From: "George L. Higgins III" <HIGGIG@mmc.org>
To: "JF@portlandmaine.gov" <JF@portlandmaine.gov>
Date: 10/13/2013 3:10 PM
Subject: Input for the upcoming Planning Bord meeting

My wife Cheryl and I are owners of one of the condominiums located at McCormick Place located on 33 Park Street. I write to add my voice and input for your consideration as the Planning Board considers the proposal to construct a 6-unit condominium complex at 133 York Street.

EROSION CONTROL AND LANDSCAPE PLAN

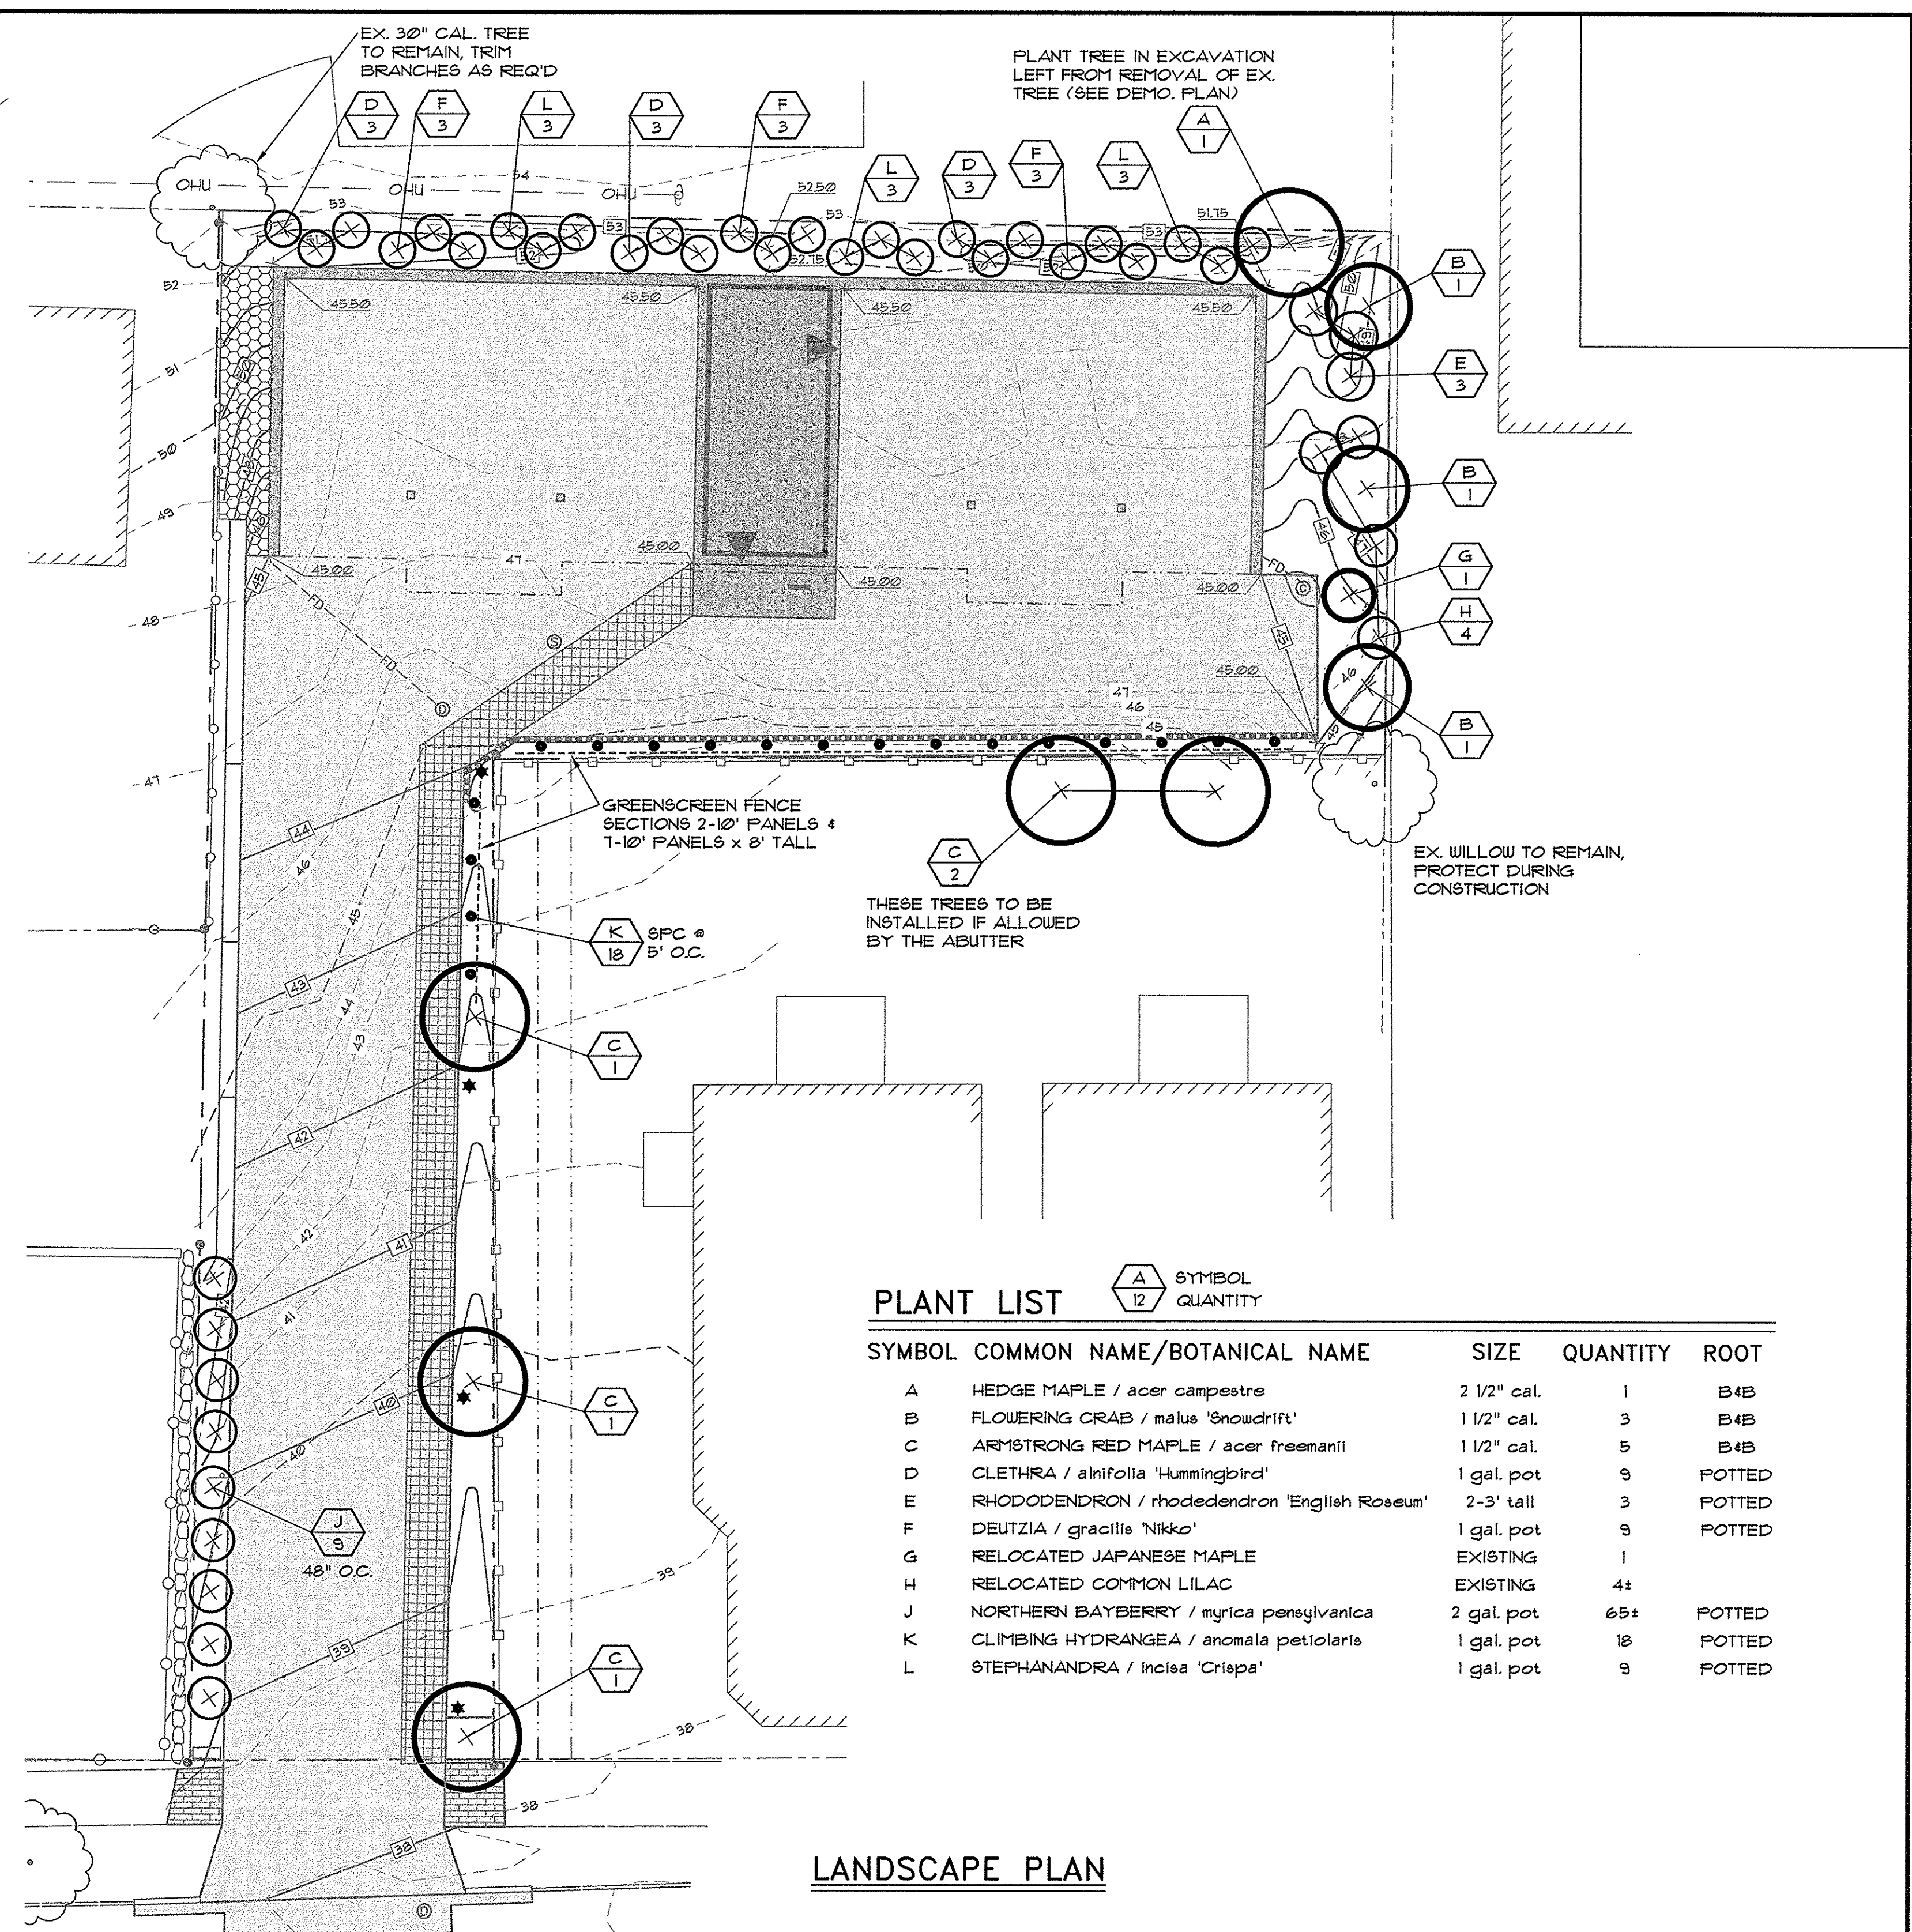
3. I know you and your colleagues do all that you can to ensure that existing trees are given optimal consideration for survival within our beautiful city. I support this postion fully and hope that trees will only be sacrificed during the York Street construction process if there is no other reasonable option.

4. Since the rear of the new proposed facility directly abuts our parking area, this will be our unobstructed view of it. I hope that the developer is considering ways to minimize the visual impact of industrial types of equipment and maximize the visual impact of buffering urban landscaping for the rear of the building. I have no doubt these issues are being considered for the front and side facades.
